# **Application by Springwell Energy Farm Ltd for an order granted development consent for the Springwell Solar Farm**

## **Written Representation**

**A report prepared by North Kesteven District Council  
(ID 20054501)**

**Planning Inspectorate reference: EN01049**

TITLE:
FIGURE 3.3B
GREEN INFRASTRUCTURE PARAMETERS
SPRINGWELL EAST

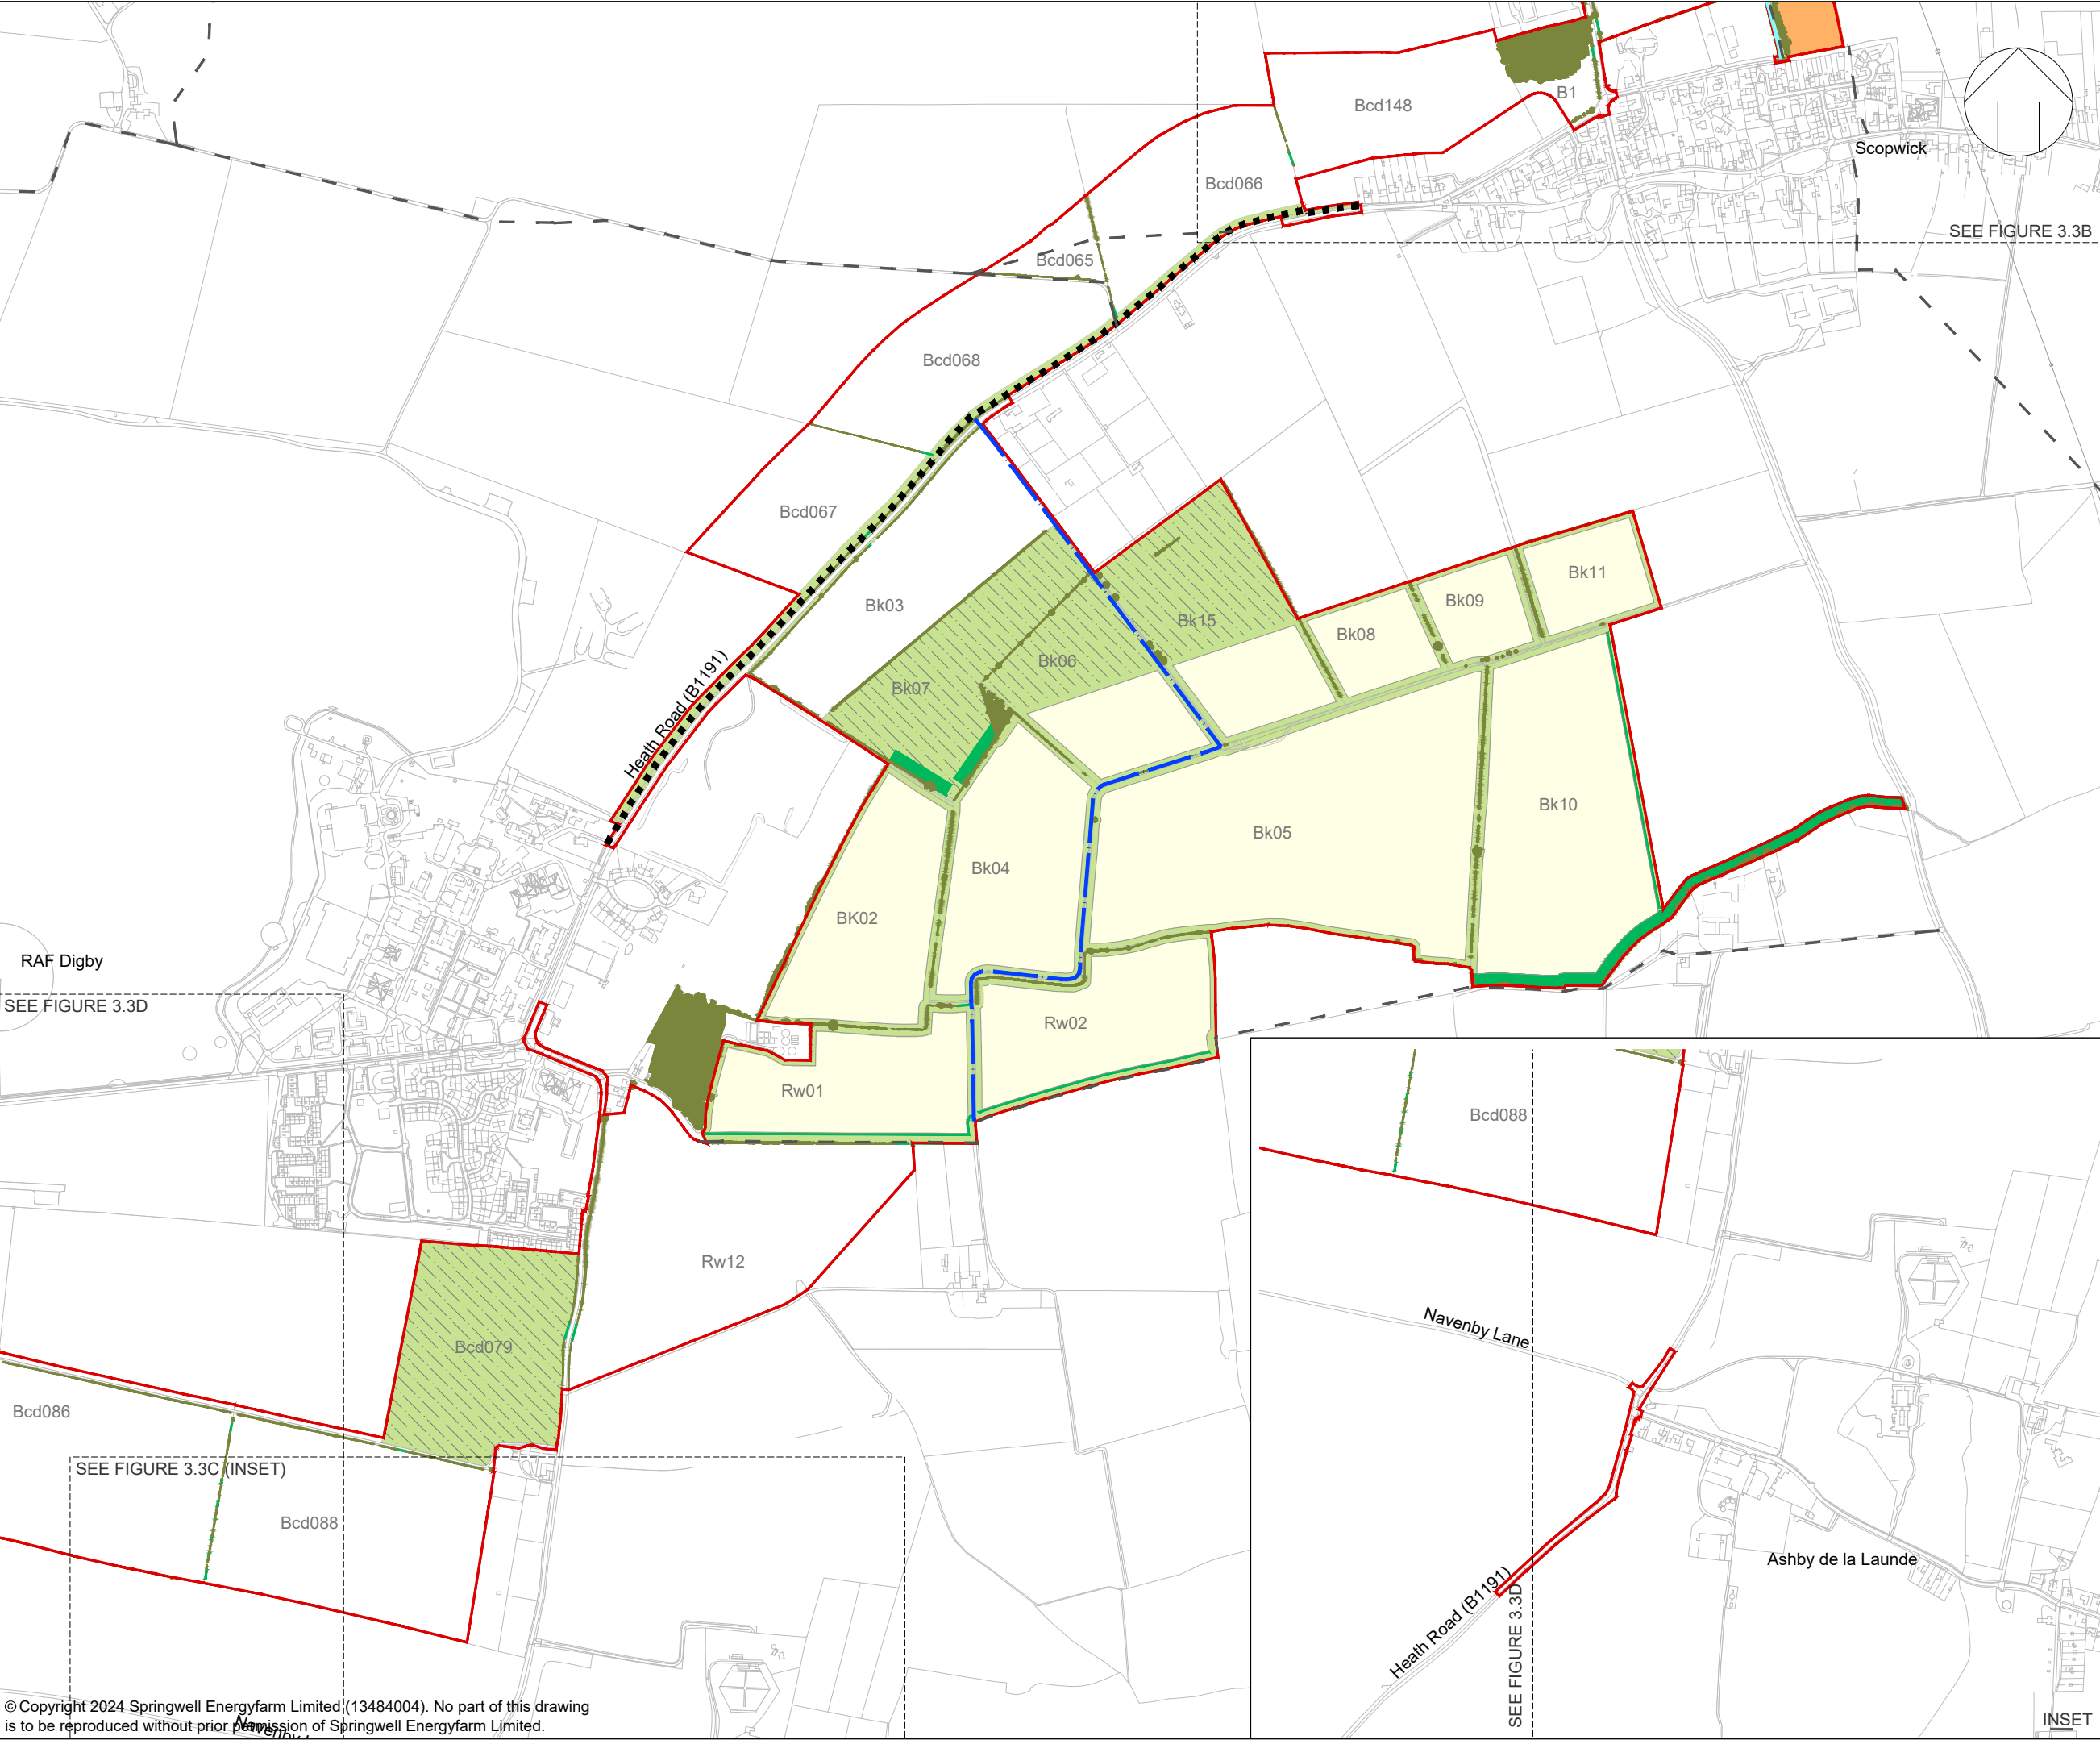
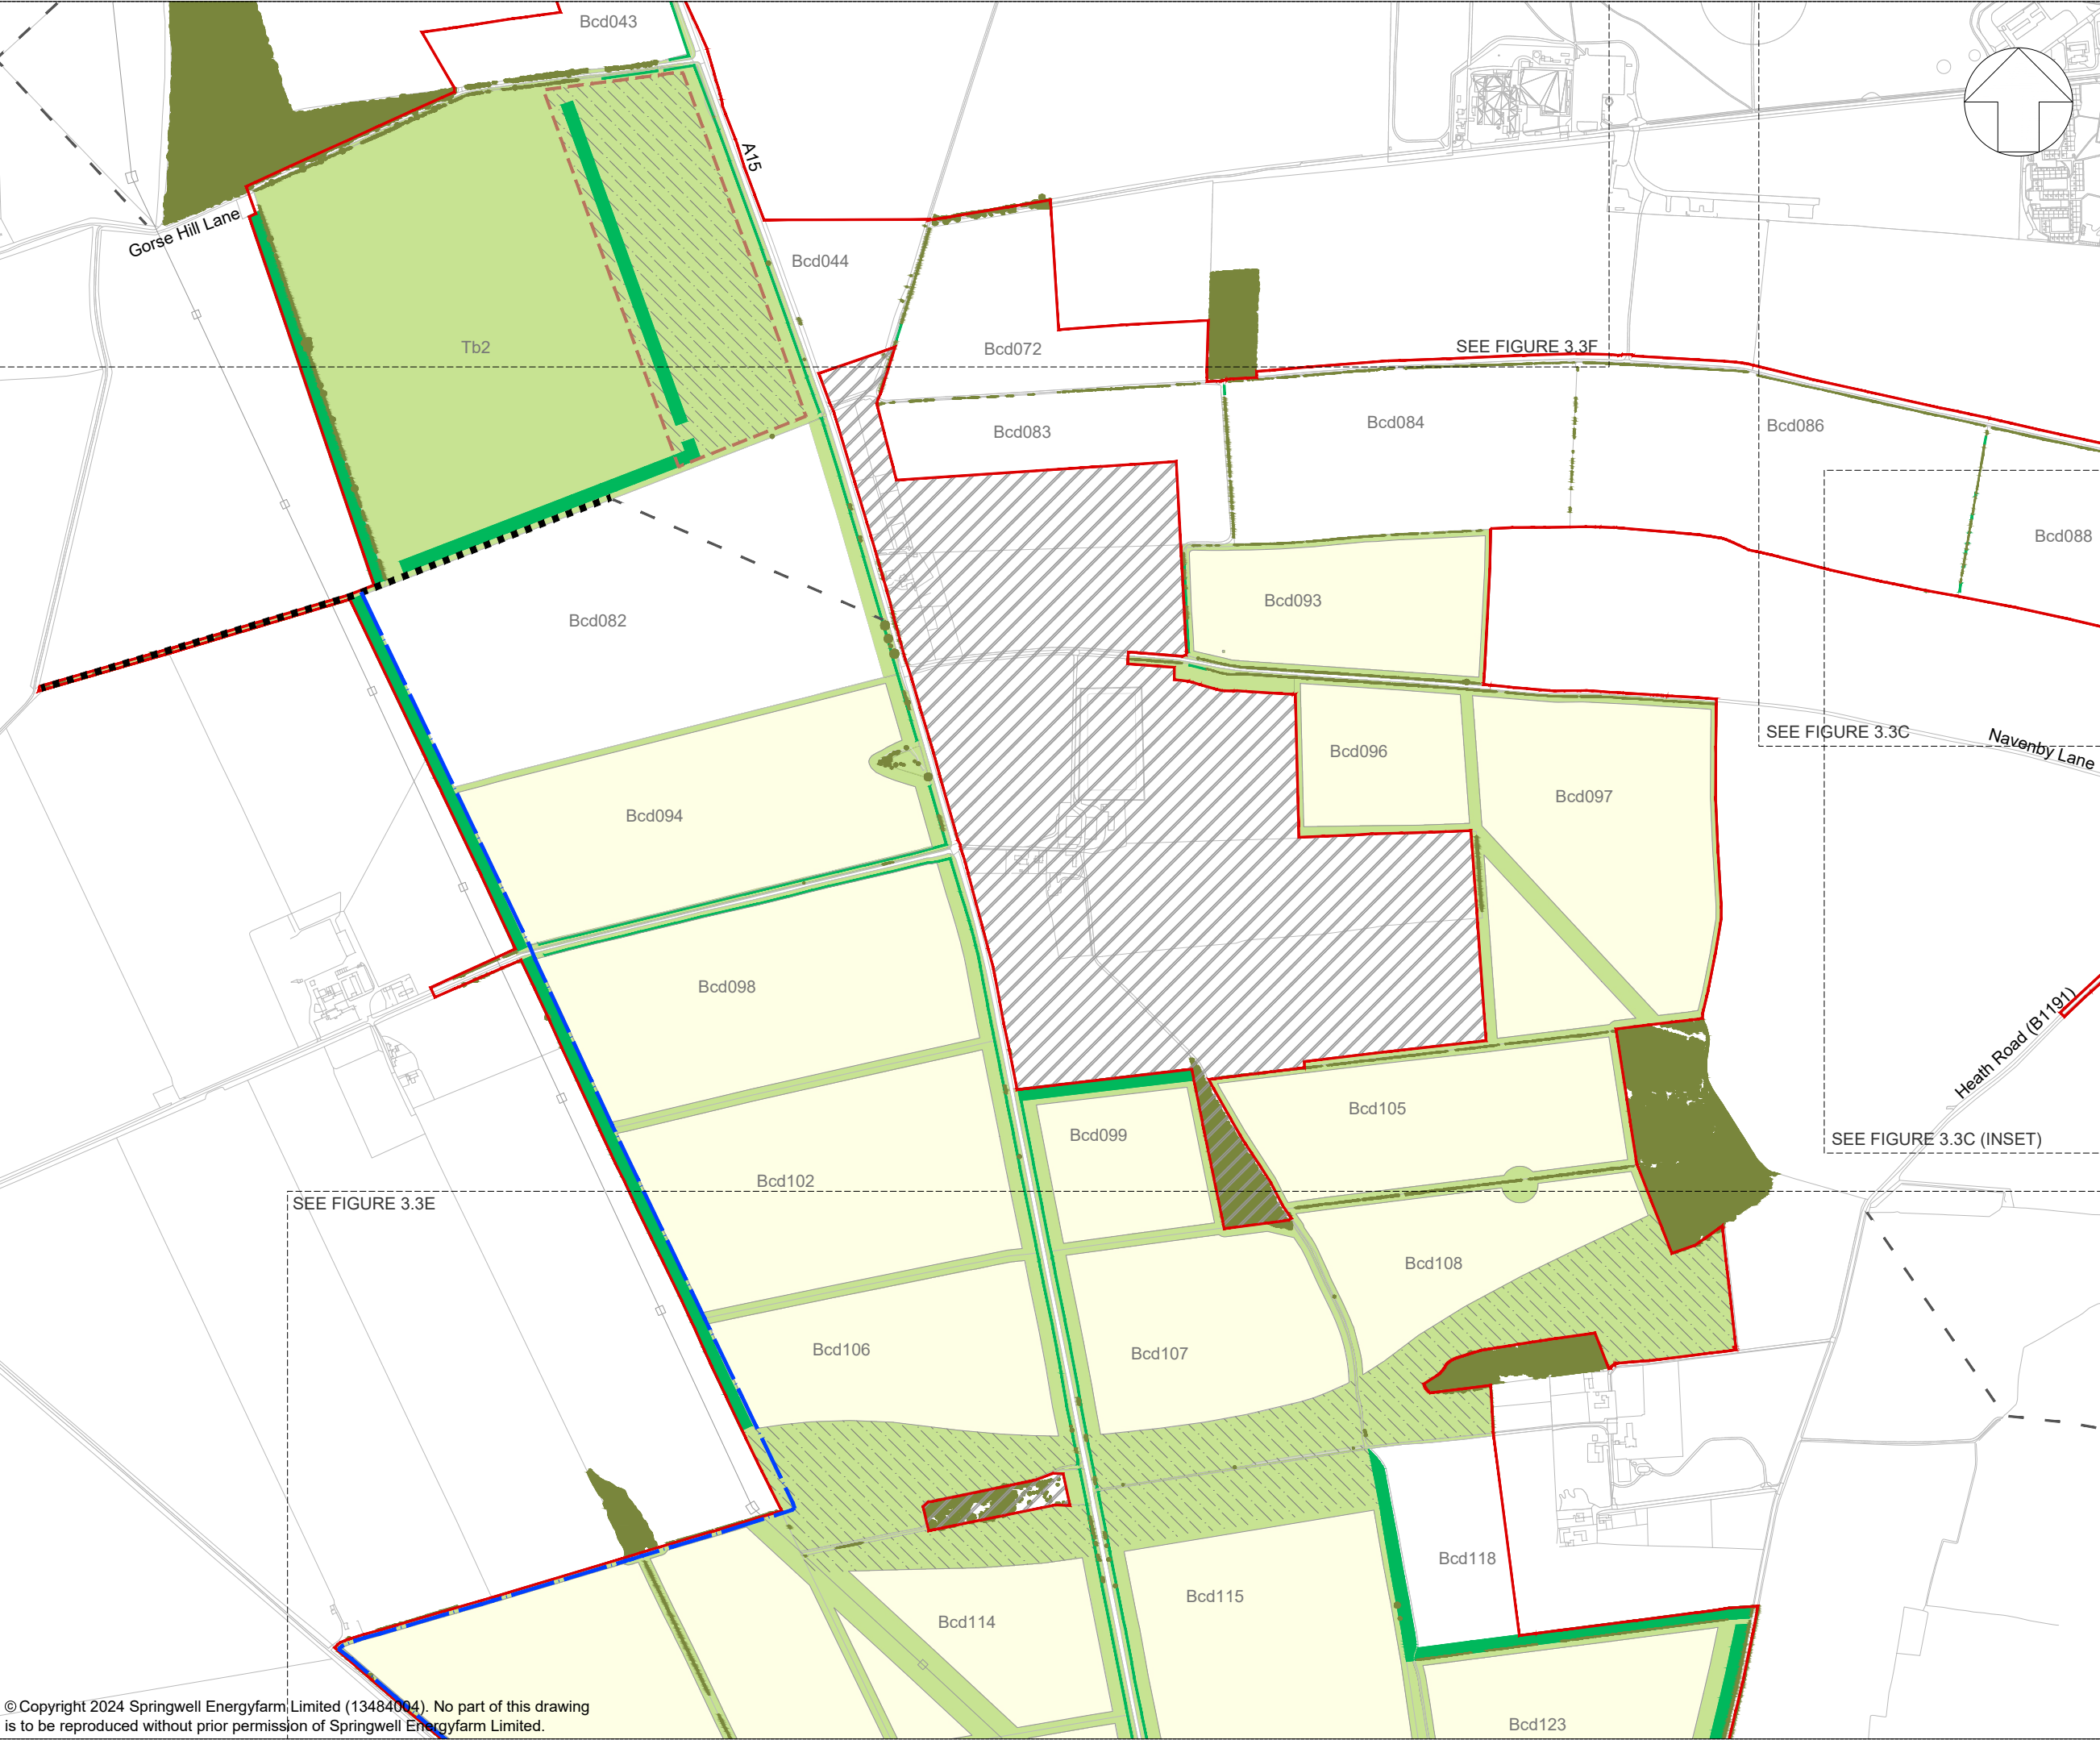
- 4.9 The BMV land to be used for temporary green infrastructure in field Tb2 (through the formation of a bund to screen the substation and BESS) and community growing area appears to be a further permanent loss of BMV agricultural land. While the land to be used as temporary green infrastructure will not be permanently sealed, it would be covered by a 3-5m bund for the duration of the solar farm. The community growing area may or may not result in a loss of BMV agricultural land. Together they would account for the further loss of up to 31ha of BMV land.
